Application for a Non-Material Amendment Following a Grant of Planning Permission

Full Planning Application - Erection of 3No dwellings and new vehicular access (following demolition of barns previously approved under Class Q DC/22/01800).

DC/23/00639

Change of external wall cladding to 'Natural unfinished horizontal Oak Weatherboarding to walls'.
Inclusion of PV panels to roof slopes.

Project:	The Piggeries, Elm Farm, Somersham Road, Lt Blakenham, IP8 4NF		
Client:	Beechlake Developments		
Drawing Title:	Plot 2 - Floor Plans and Elevations as Proposed		
Drawing Number:	PW1284-PL05 rev D		
Drawing Status:	Planning	Drawn By:	AAB
Scale:	1:100 (at A1)	Date:	09/01/2023

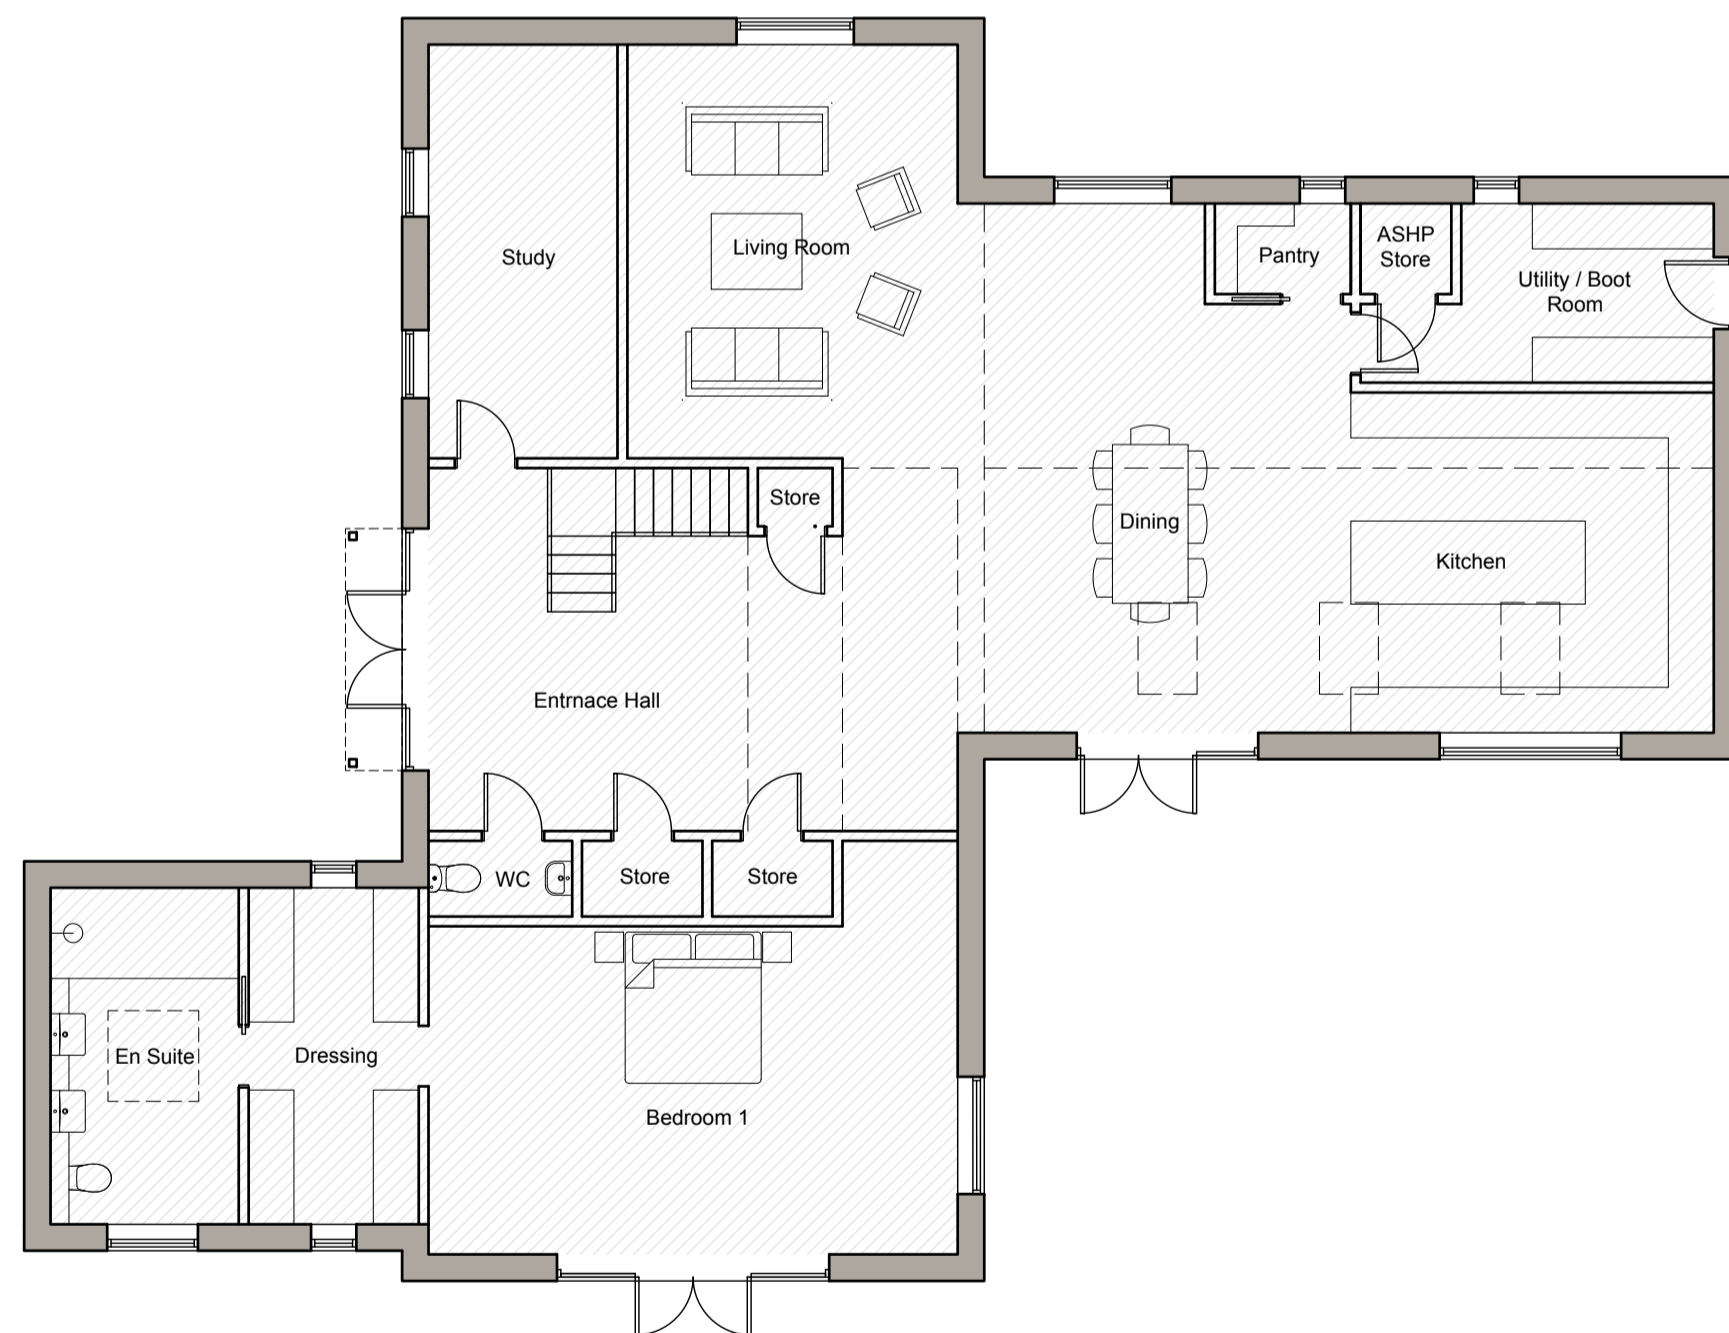
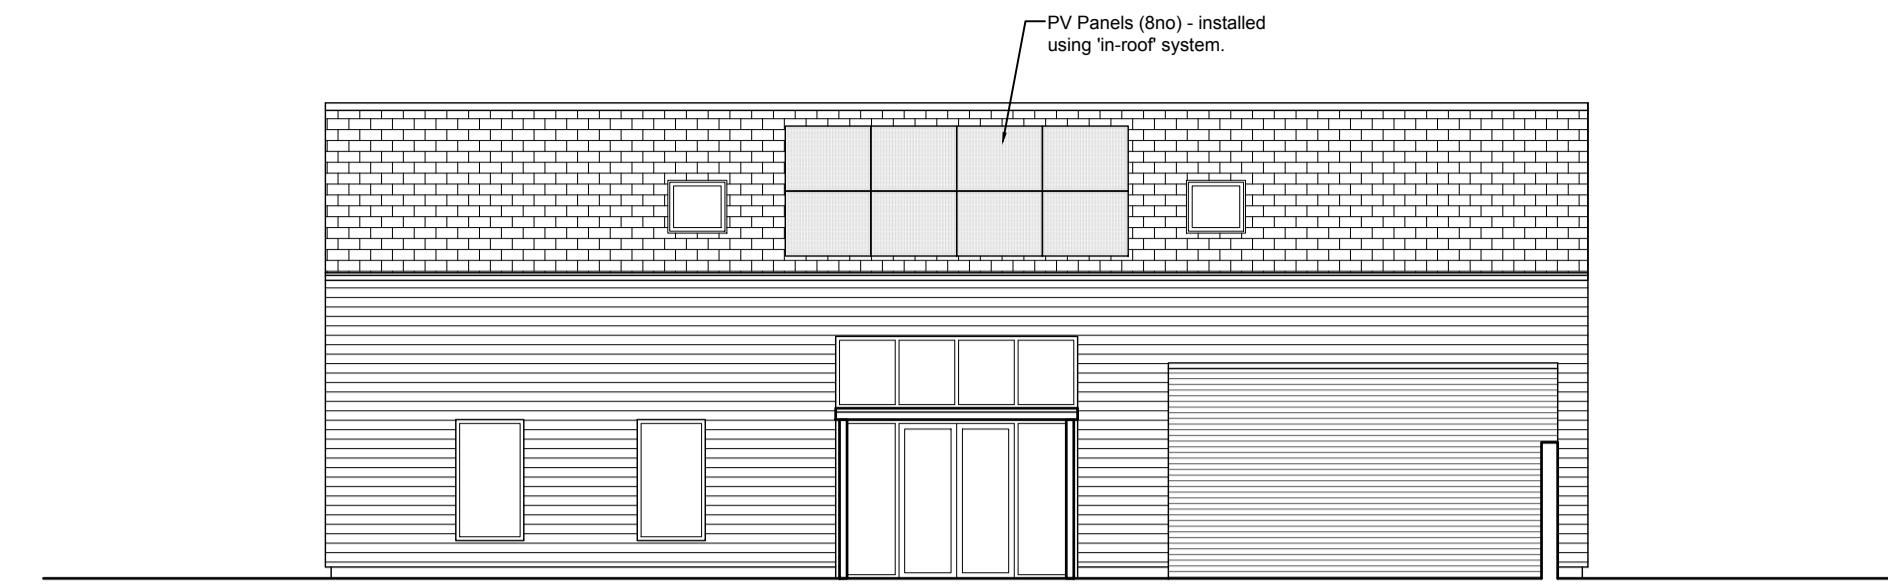
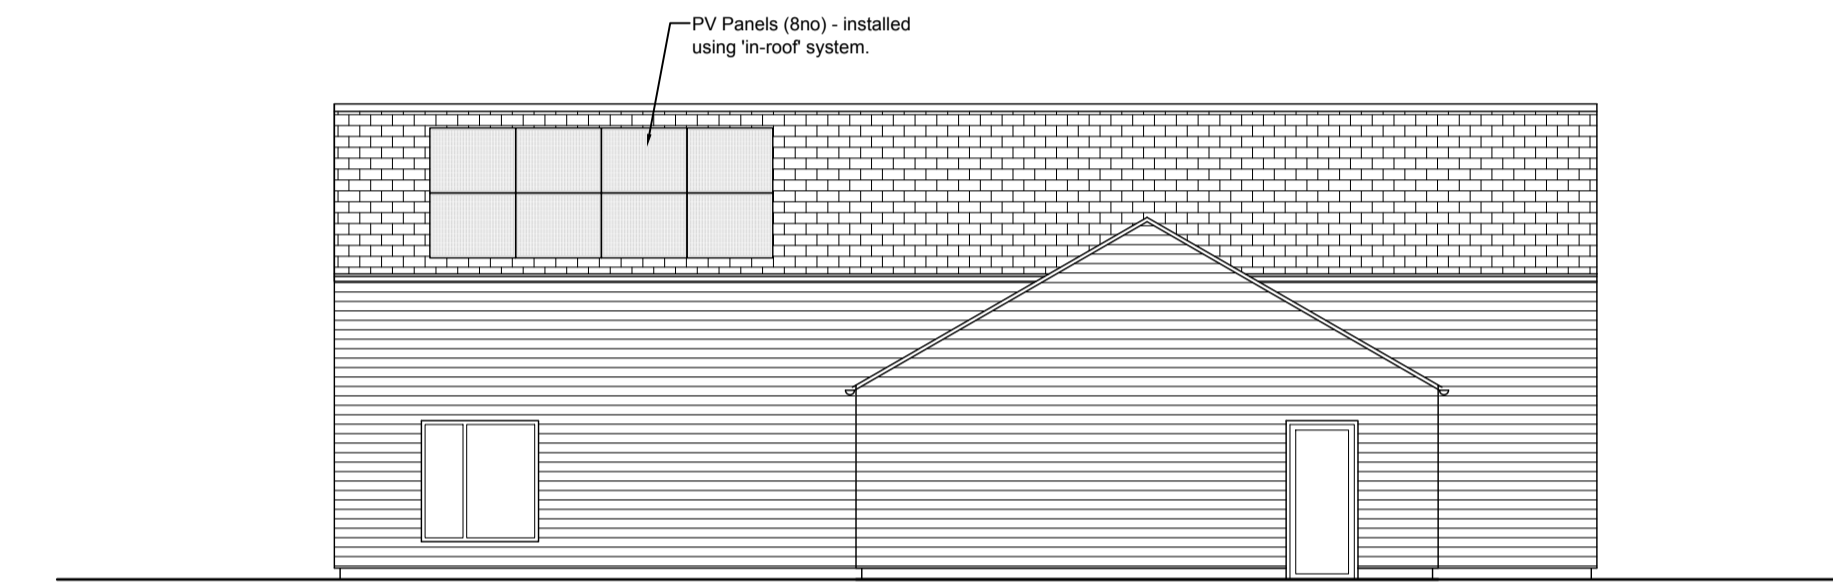
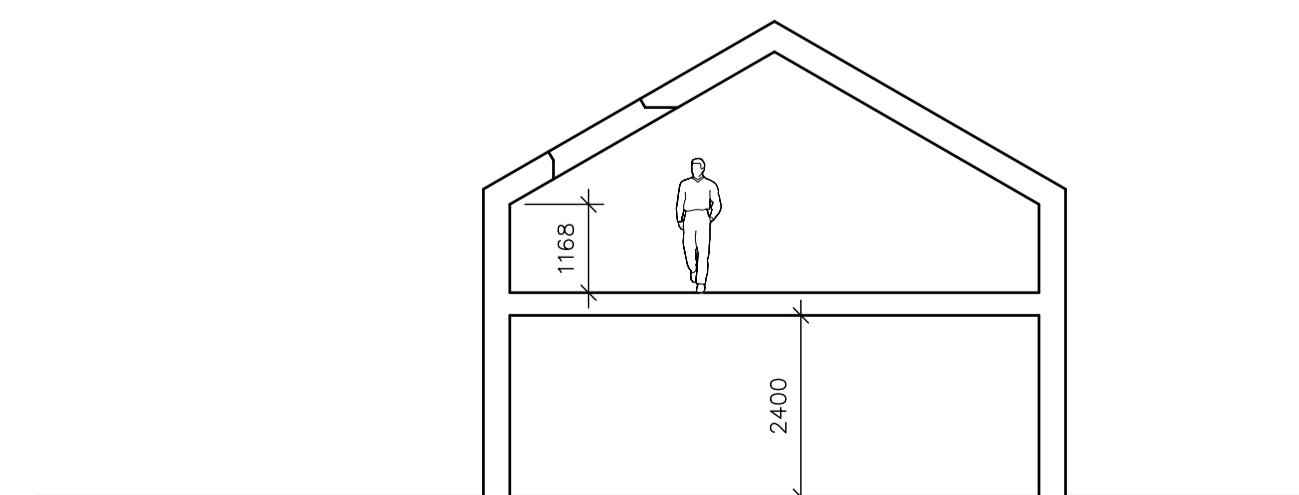
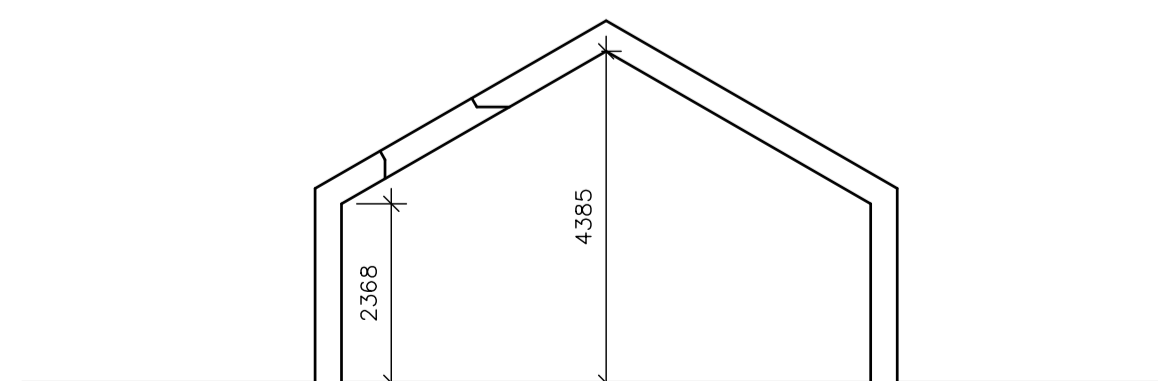
To enable to the use of Oak horizontal cladding, which matches the neighbouring property and is preferred by the developer.
To enable the use of PV panels, to ensure that the dwelling achieves an A rated energy performance.
